From: Nigel Hunston
Sent: 24 March 2017 12:31
To: DCAdmin
Cc: Anna Blaxall
Subject: 2017/90670 & 2017/90671 at location 246, Fleminghouse Lane, Almondbury, Huddersfield, HD5 8TY

The application forms state that pre-application advice has been sought from myself, where I stated that “extension-glass lightweight/contemporary approach (honest)” and “conservation roof light in original roof (18' x 1m CR9/7)”. Whilst I cannot recall giving such advice I fail to see from this advice how they have arrived at this submission. I am not adverse to an extension and I am supportive of the roof lights (subject to further details being provided), retaining wall, door and to some degree the door screen however, I am not supportive of a two storey extension or to the bi-folding doorset.

PROPOSED ROOF PLAN
SCALE 1:50

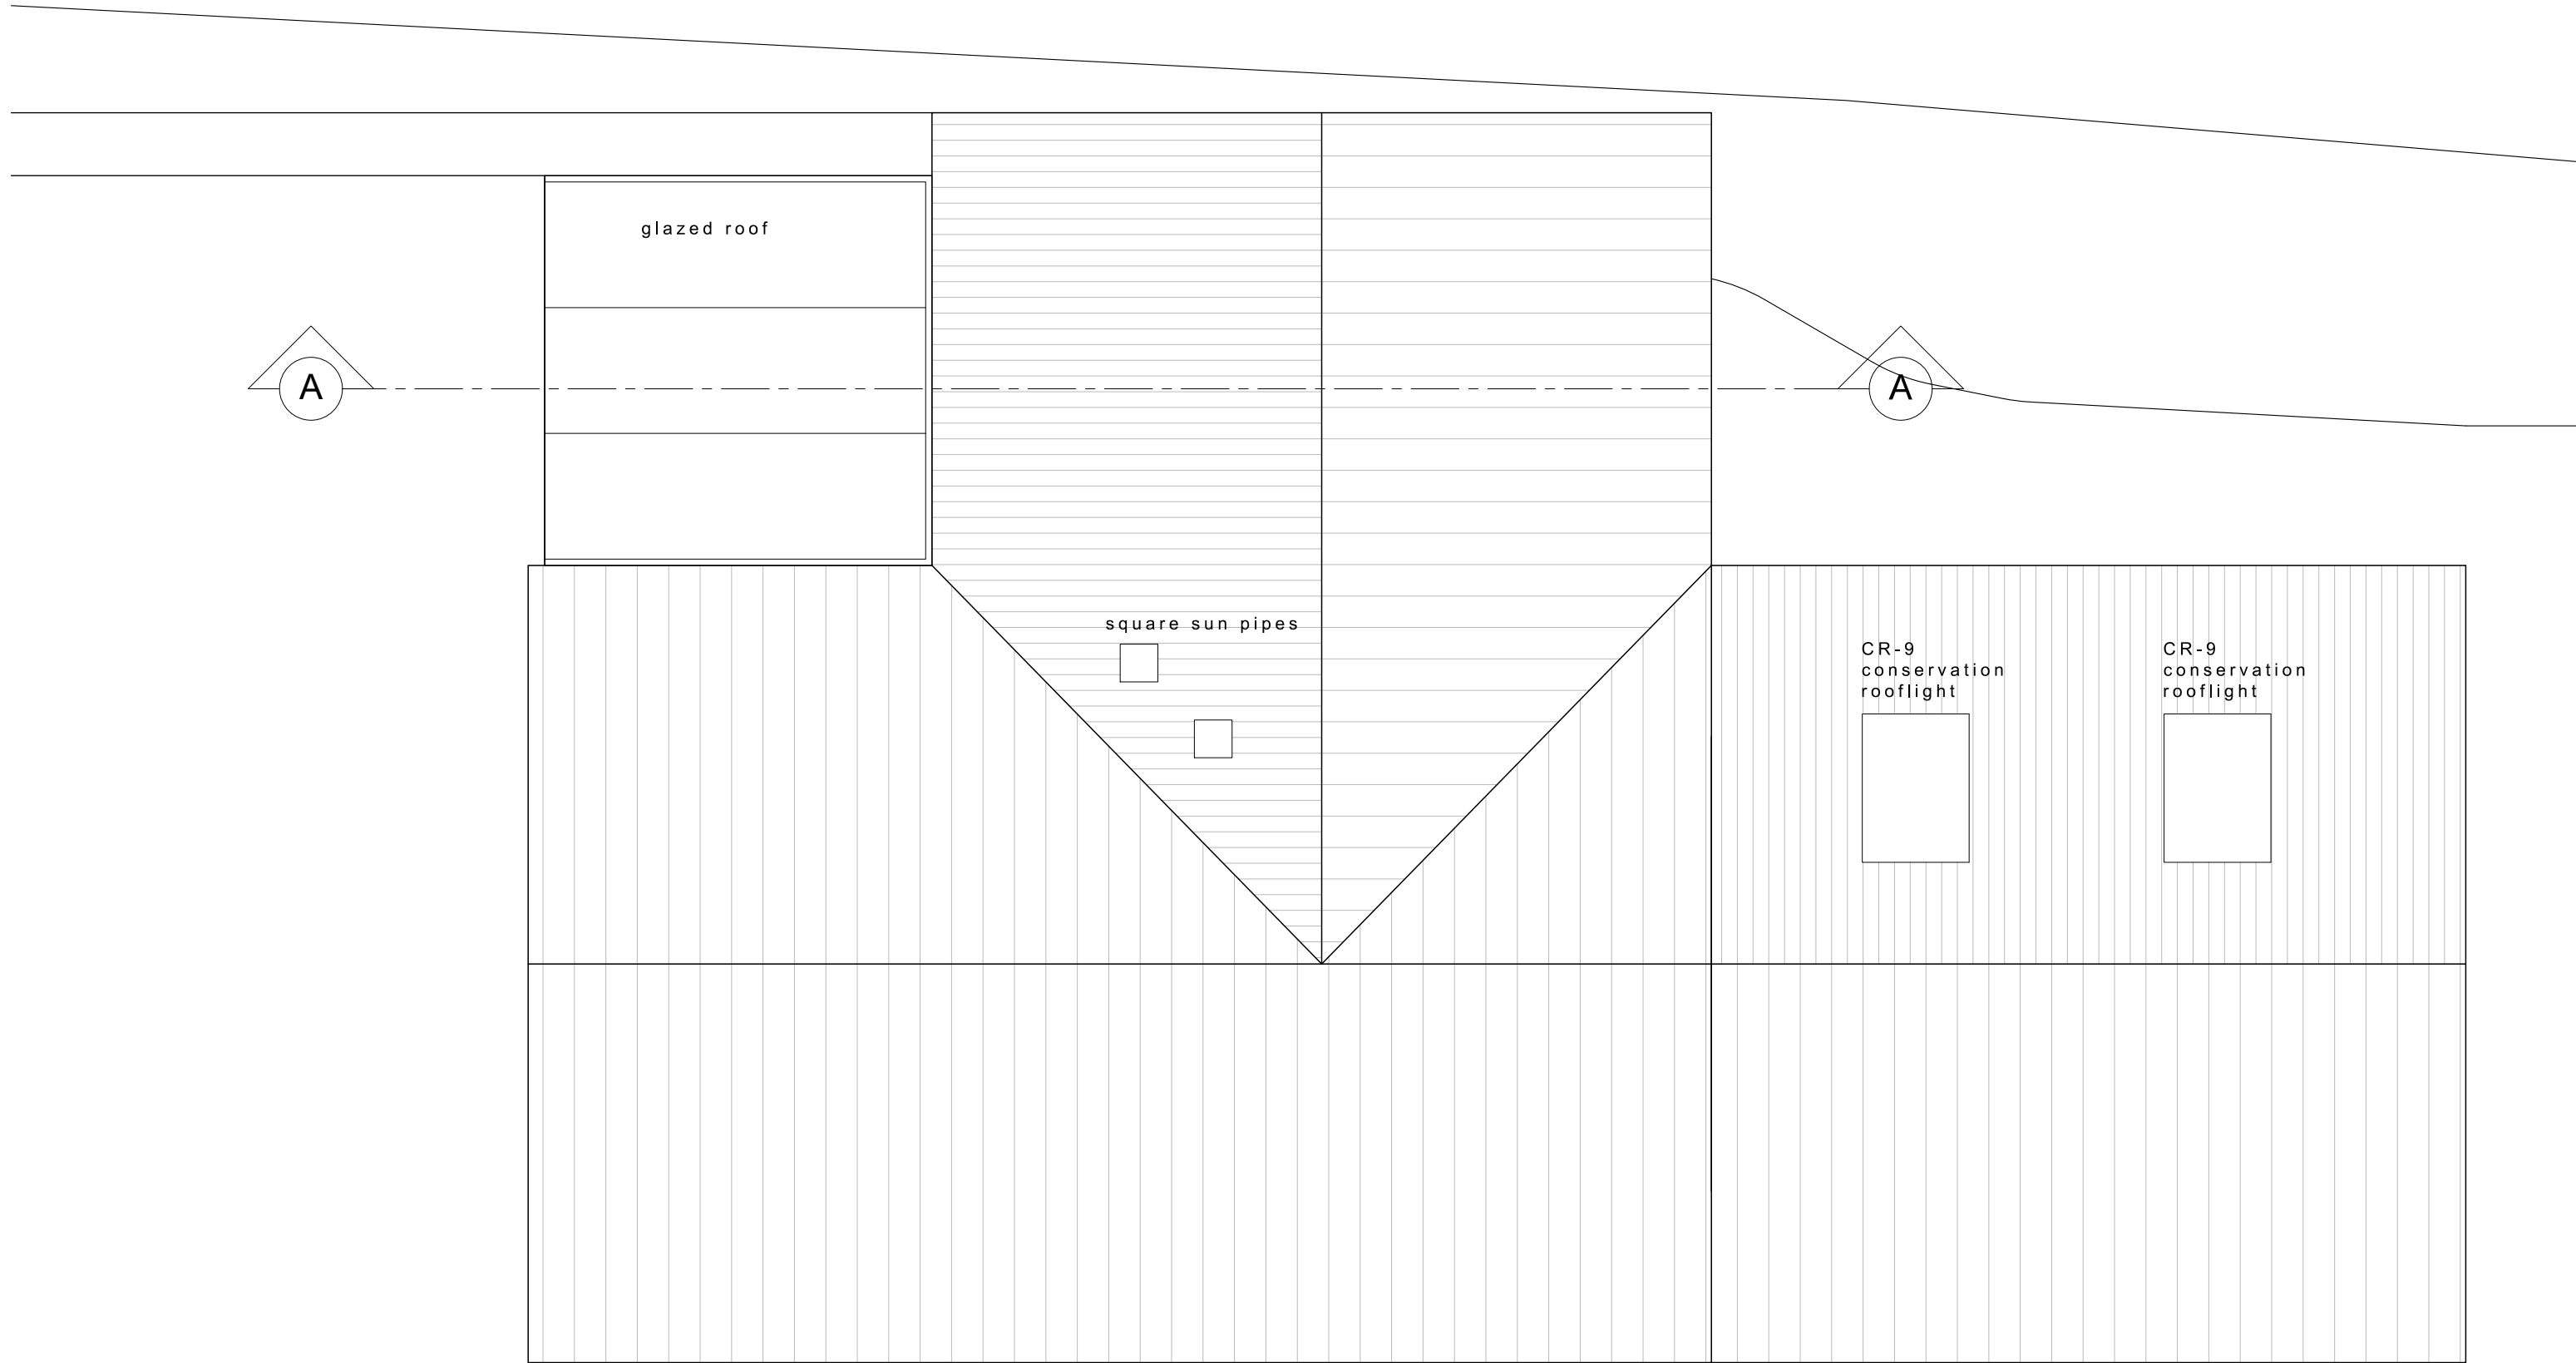
In terms of the roof lights, details of the type and installation method is required. I cannot see an extension of such scale and material being satisfactory and fails the tests laid down in the NPPF. Equally the Heritage Impact assessment provides little justification for the work. I am of the opinion that the proposal is contrary to Section 16 (2) of the Planning (Listed Buildings and Conservation Areas) Act 1990 as it fails to preserve the building as a structure of special architectural or historic interest.
